**From:** Contact Centre (CRM) <contact@ribblevalley.gov.uk>  
**Sent:** 04 February 2025 13:31  
**To:** Planning  
**Subject:** Planning Application Comments - 3/2024/1016 FS-Case-684623990

**Planning Application Reference No.:** 3/2024/1016

**Address of Development:** 1 to 7 The Picture House George Street Whalley BB7 9TH

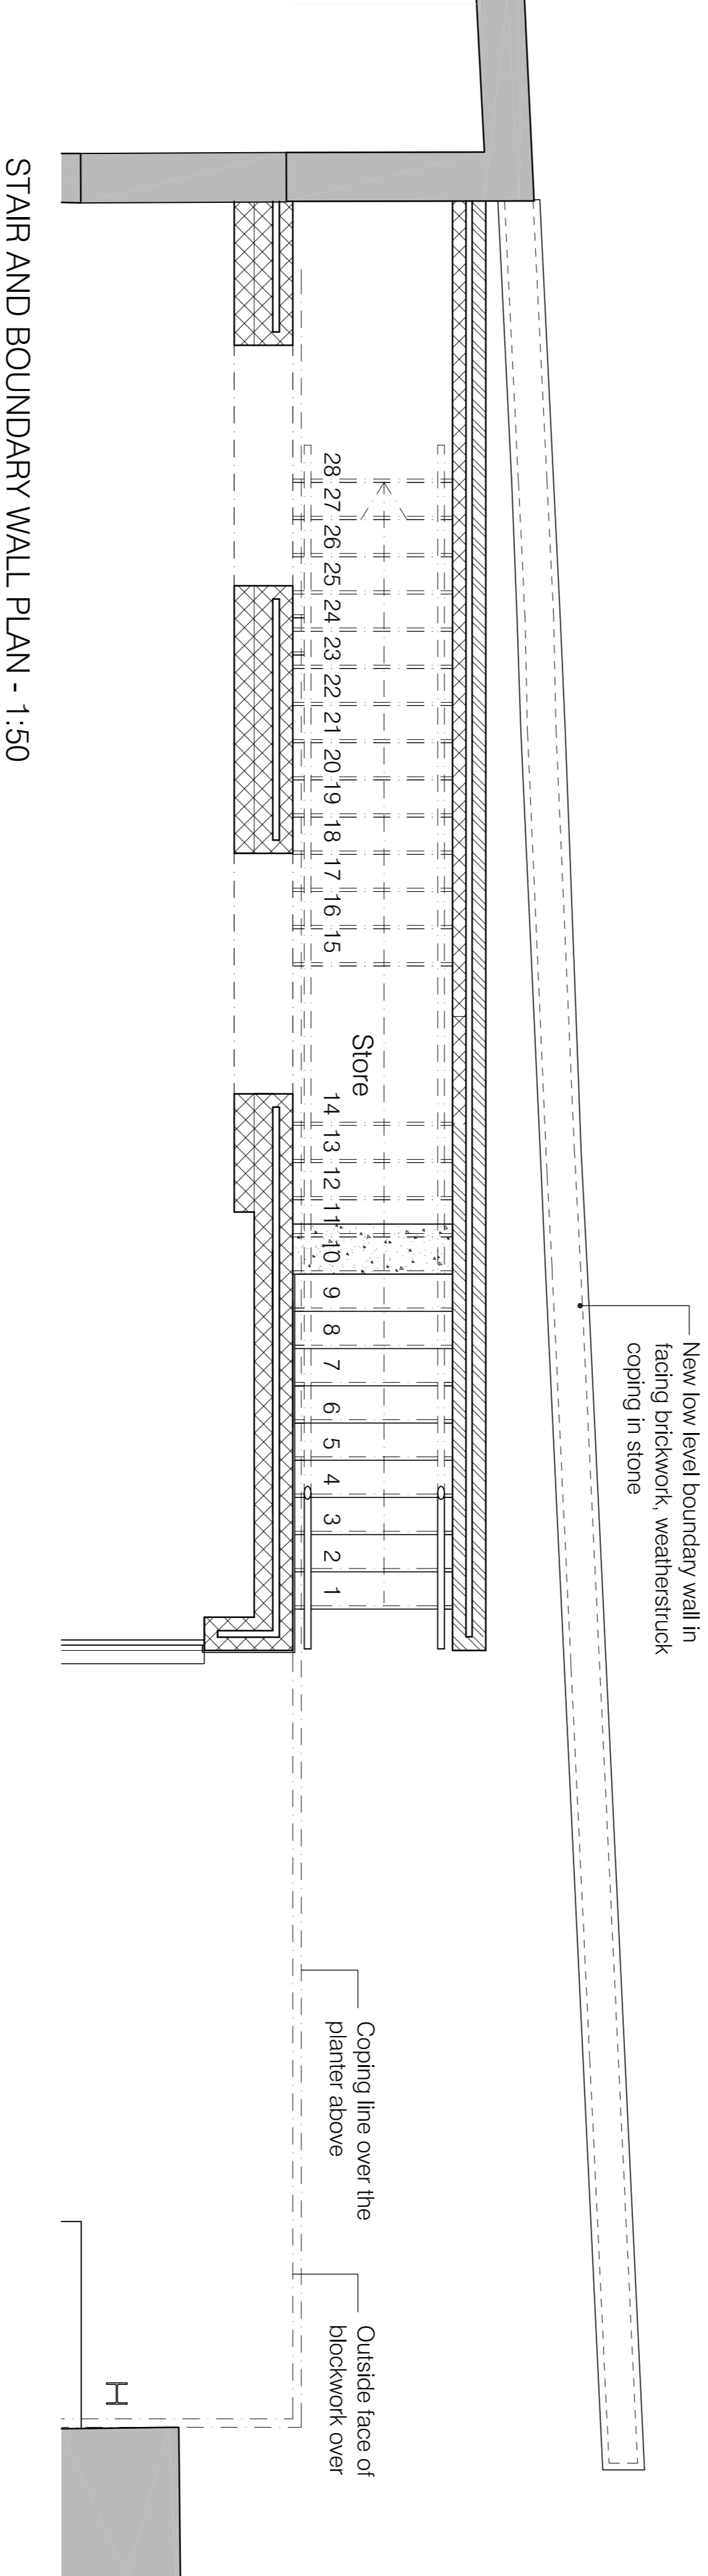
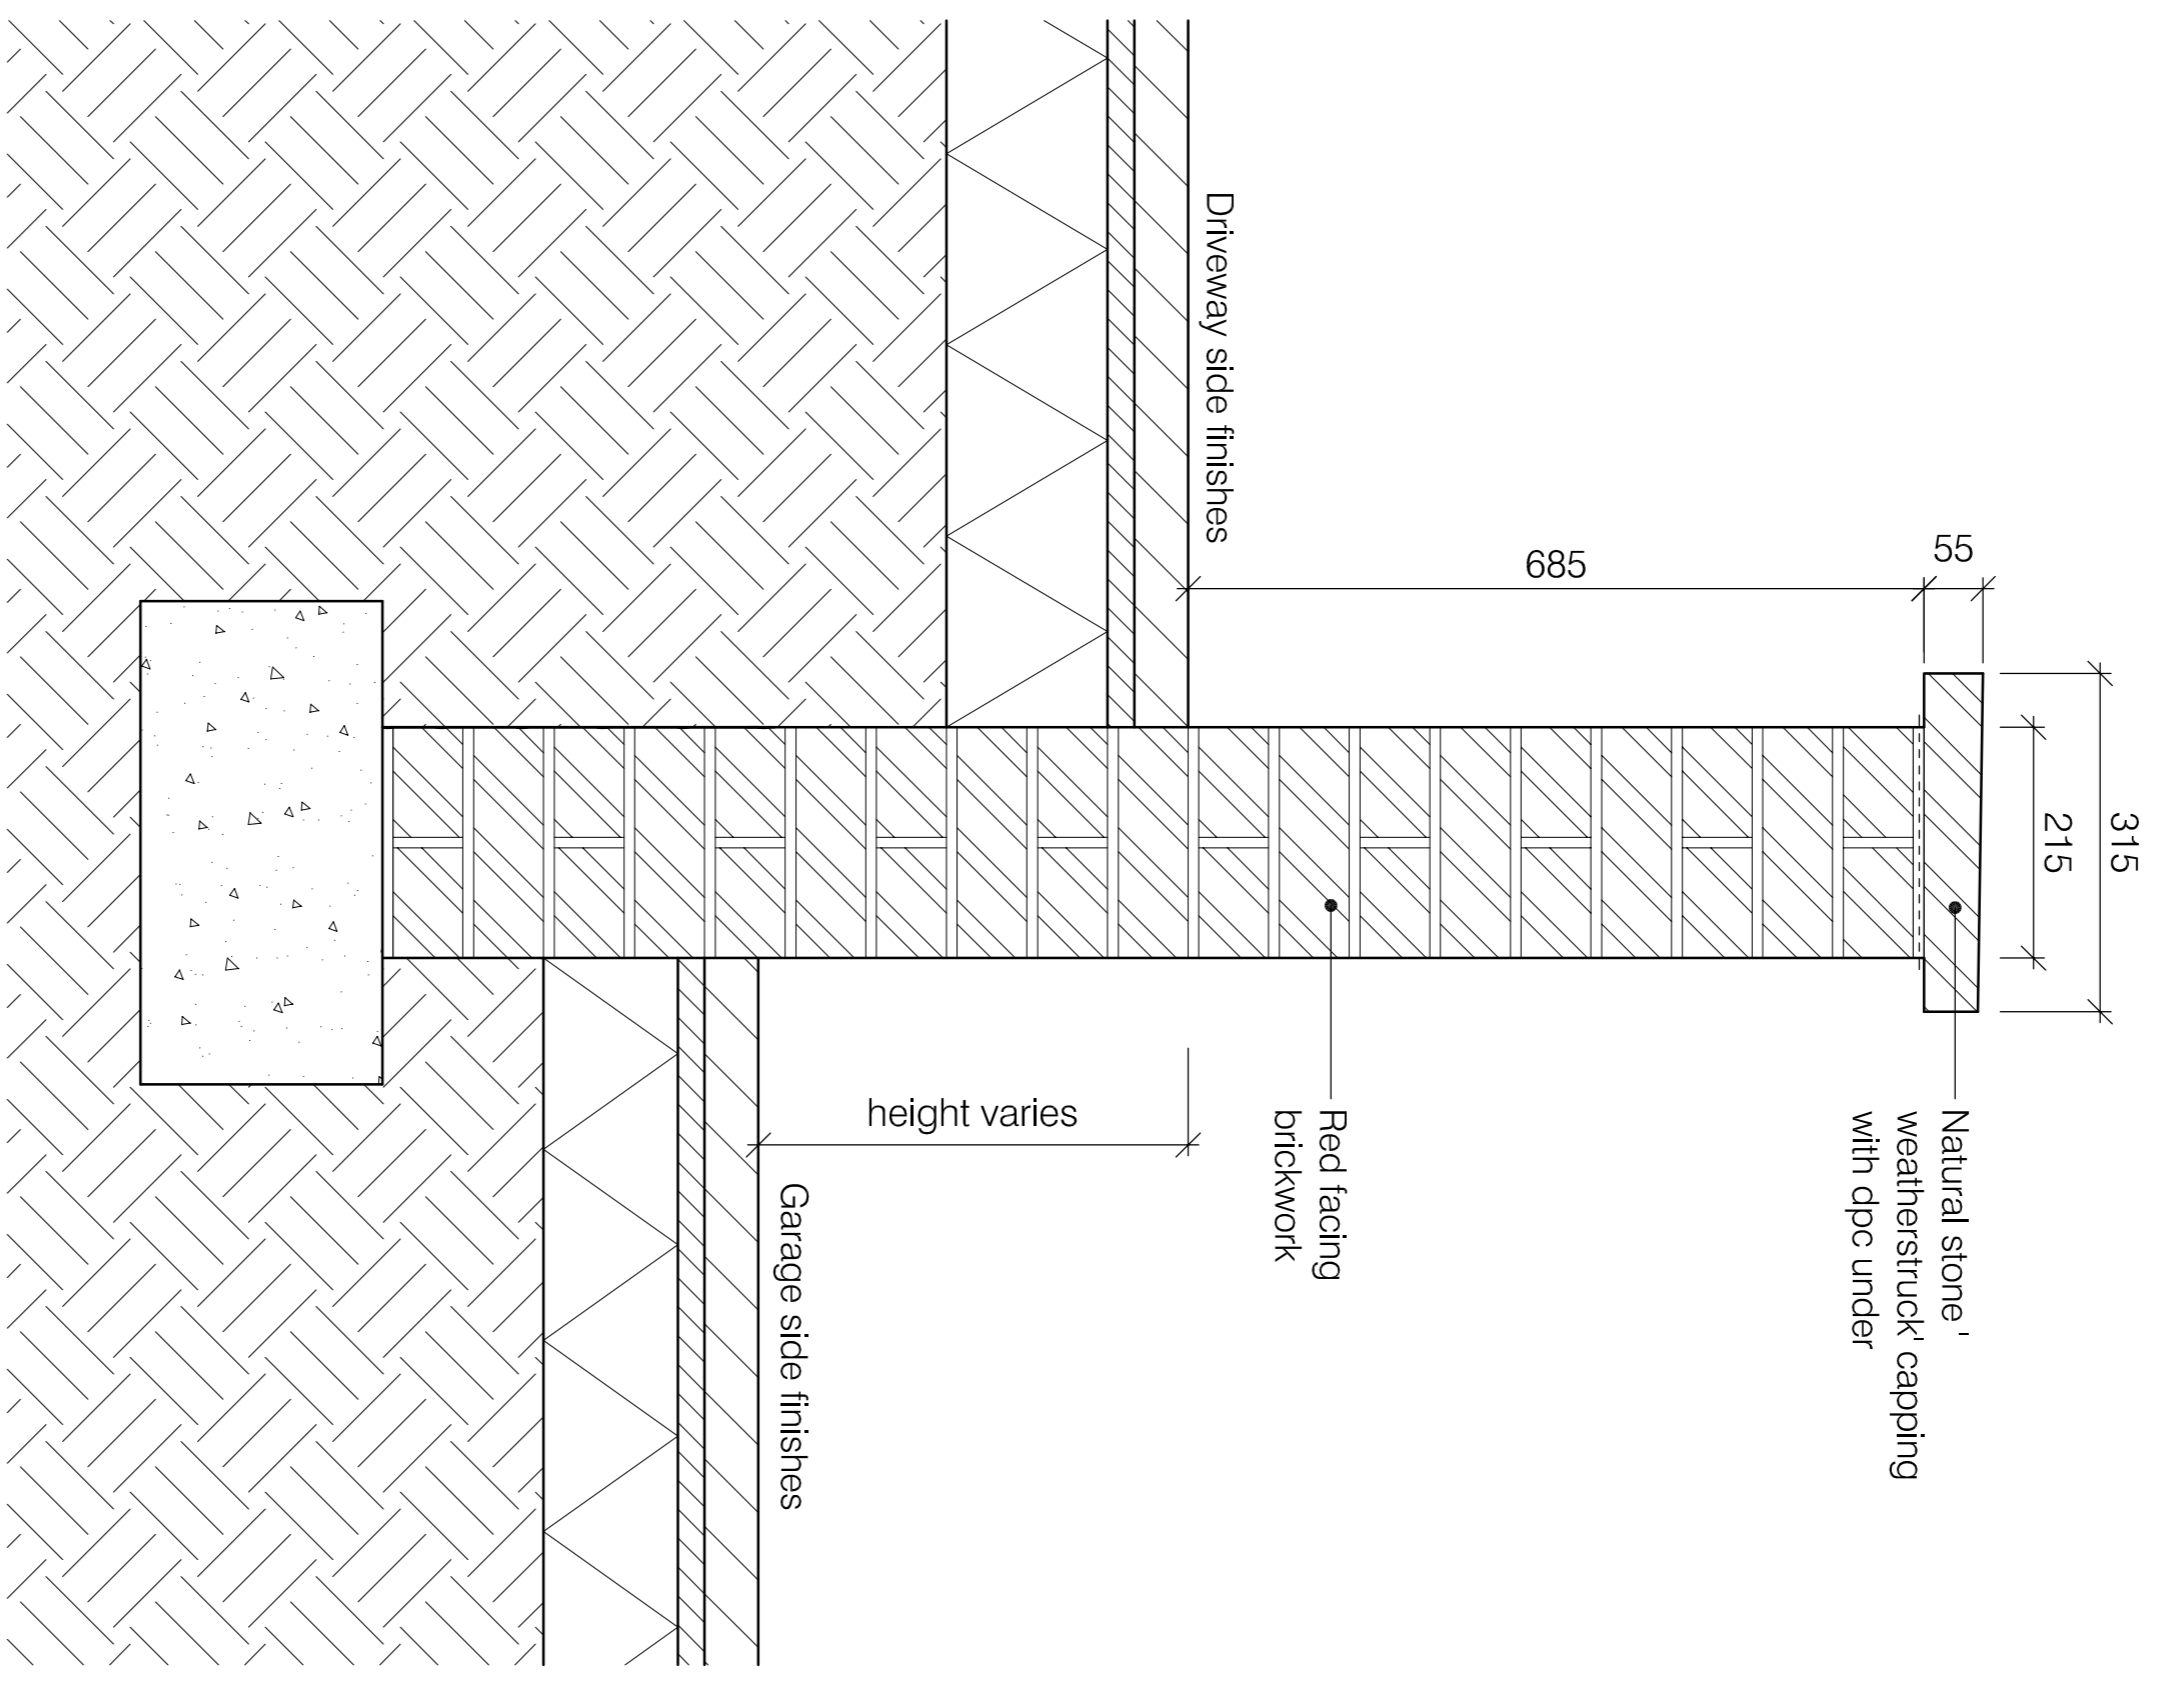
**2. Rear Boundary Wall**

The reinstatement of the rear boundary wall to 0.74m in height, while claimed to match the original footprint, raises significant concerns. The height is still disproportionate to the surrounding environment, and this aspect of the development would cause a further enclosure of the space, impacting both the character of the area and the experience of neighbouring residents. Furthermore, this reinstatement has not been demonstrated as necessary or proportionate in terms of the benefits it purportedly brings.
